Our ref: HA/2014/116106/02-L01
Your ref: BE/95/14/DOC
Date: 19 September 2014

APPLICATION FOR APPROVAL OF DETAILS RESERVED BY CONDITIONS 3 (SURFACE WATER DRAINAGE) AND 6 (SUSTAINABLE DRAINAGE PRINCIPLES) FOLLOWING A GRANT OF PLANNING PERMISSION BE/61/13/. OLDLANDS FARM STEYNING WAY BOGNOR REGIS PO22 9NN

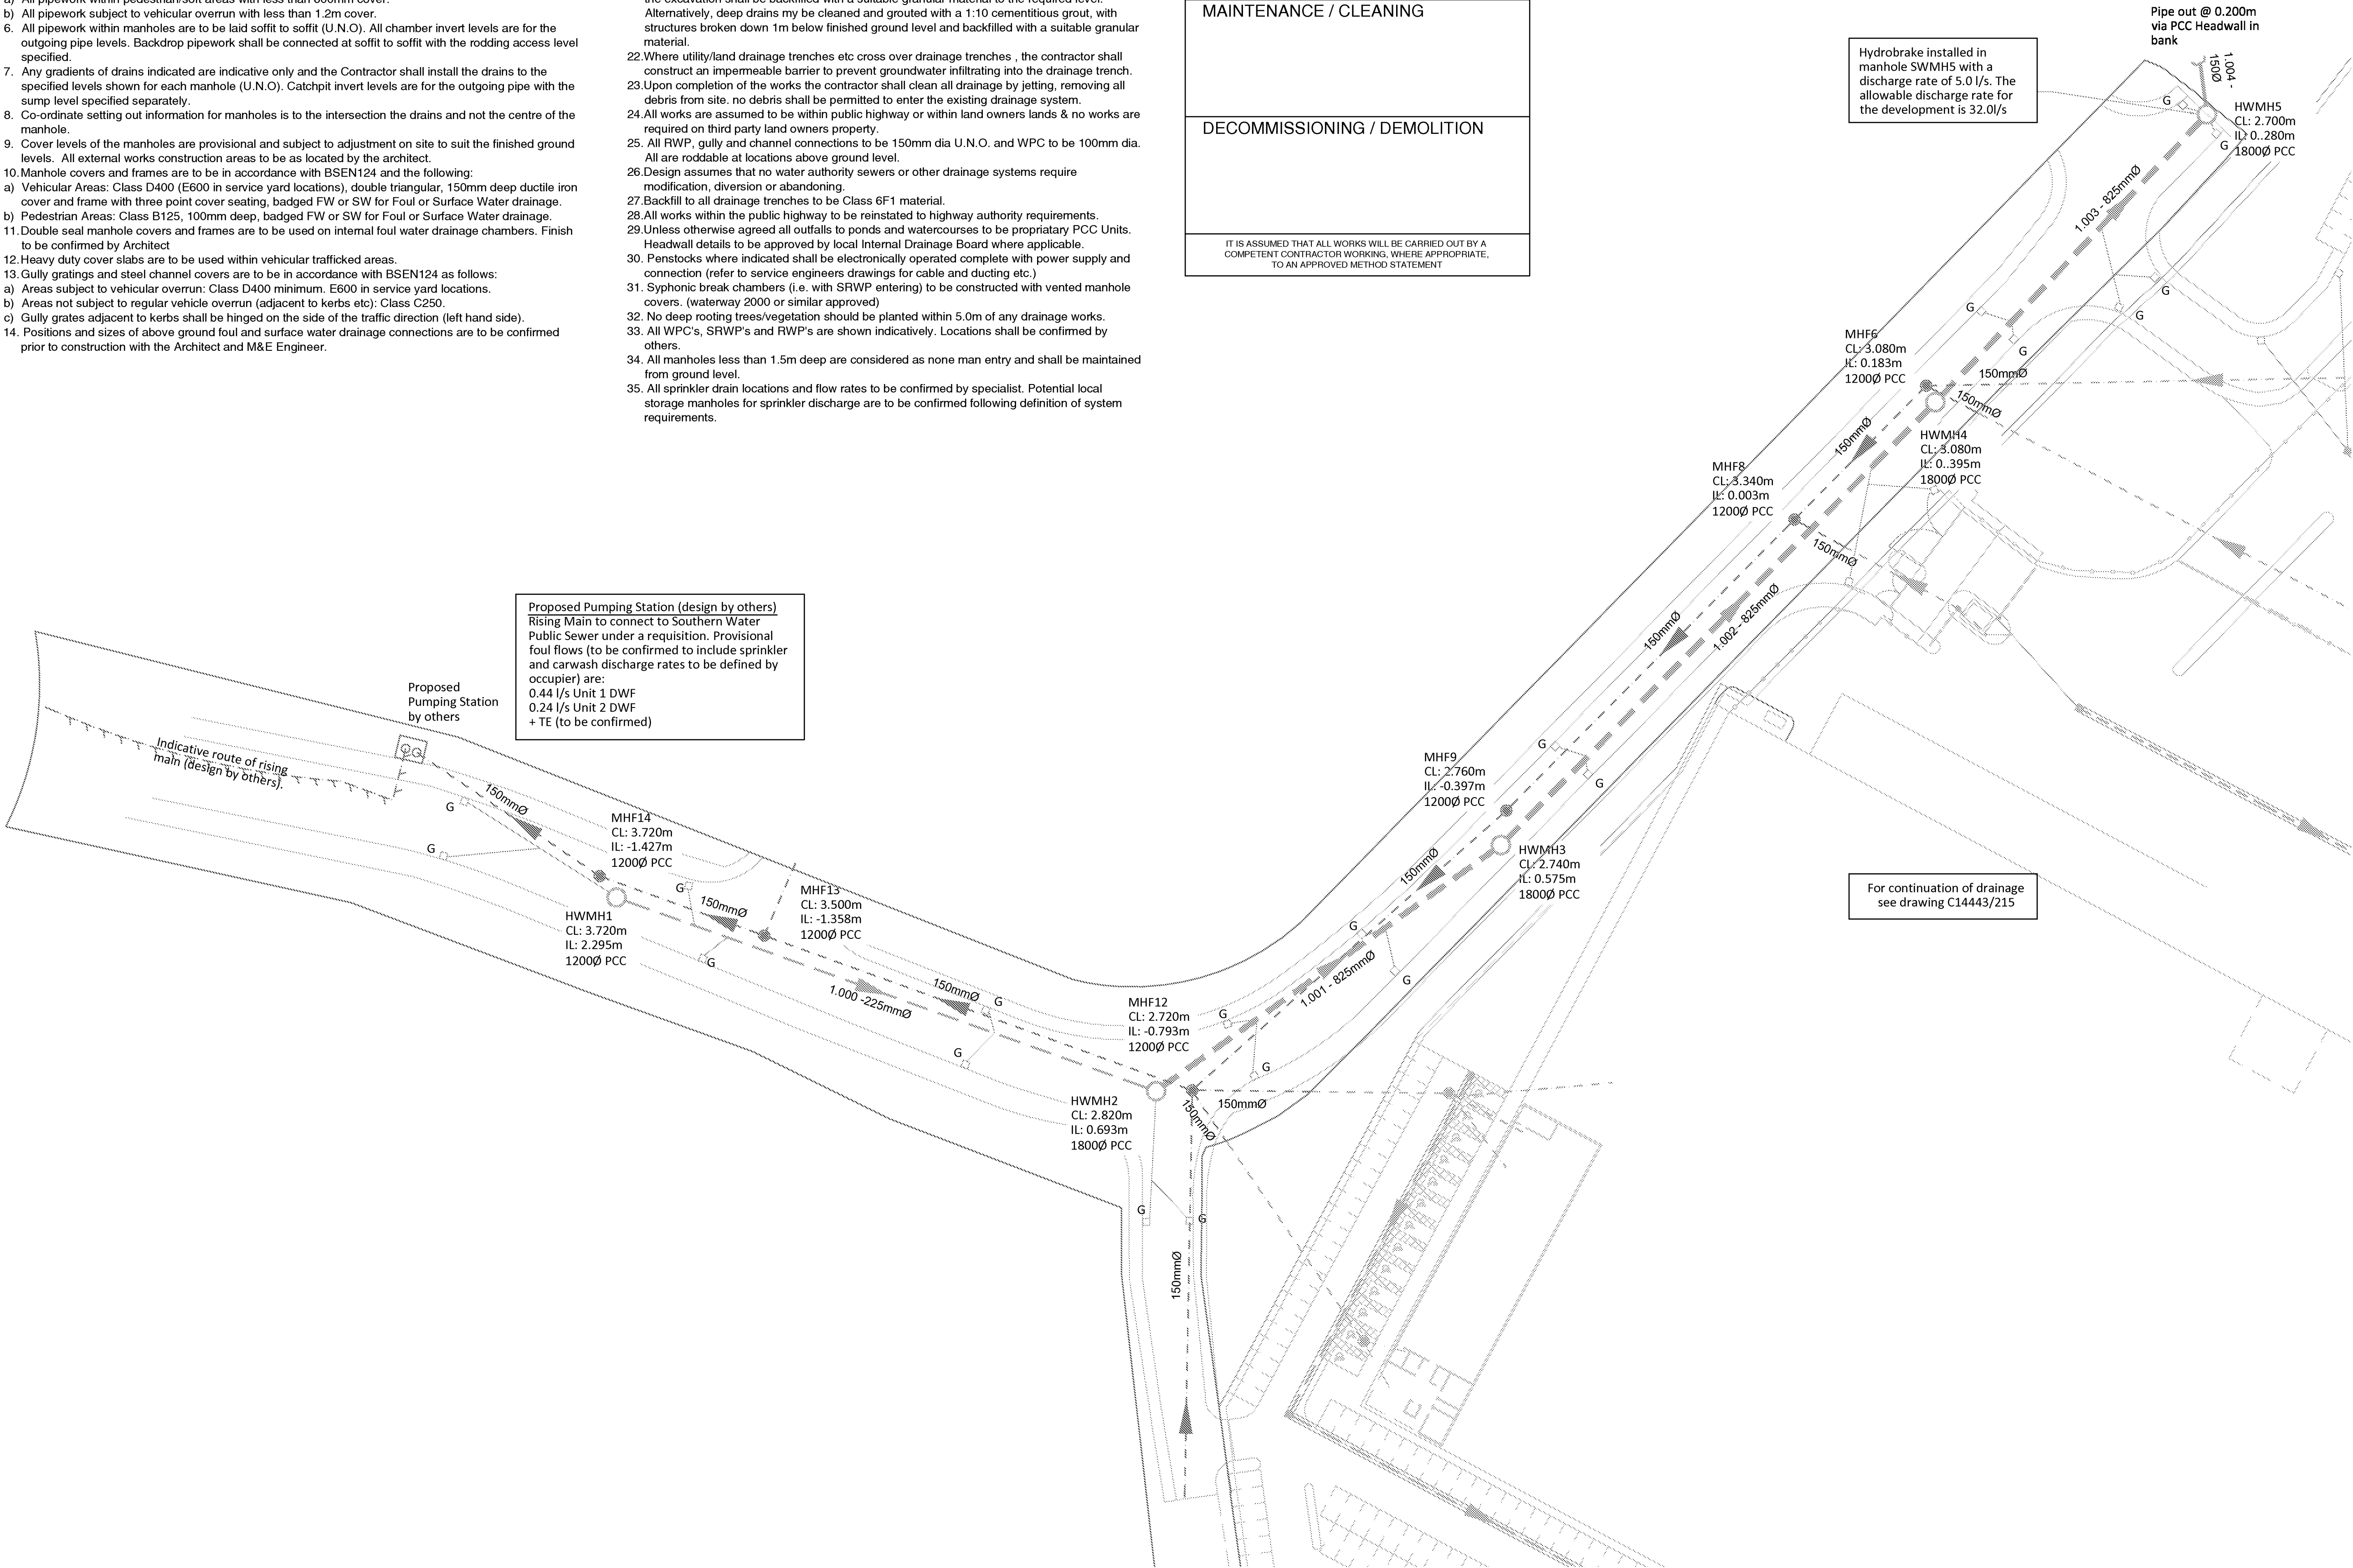
The information submitted has stated that due to the low pollution potential, trapped gullies will only be incorporated in to the design before discharge to a hydrobrake and then to surface watercourse. However no information has been submitted to detail what the low pollution potential is by means of traffic numbers and type of potential pollution.

We understand the lack of available land means that a traditional SUDs system using a pond is not available, though a pond is not the only means of pollution prevention in a treatment train process. While this is standard for this type of scheme, developers should endeavour to design best available system to prevent pollution. We consider the incorporation of trapped gullies as the minimum pollution control device available. Though we consider the information sufficient to enable us to recommend the discharge of Condition 6, we would highlight that the incorporation of other suitable devices such as a downstream defender could have been considered.
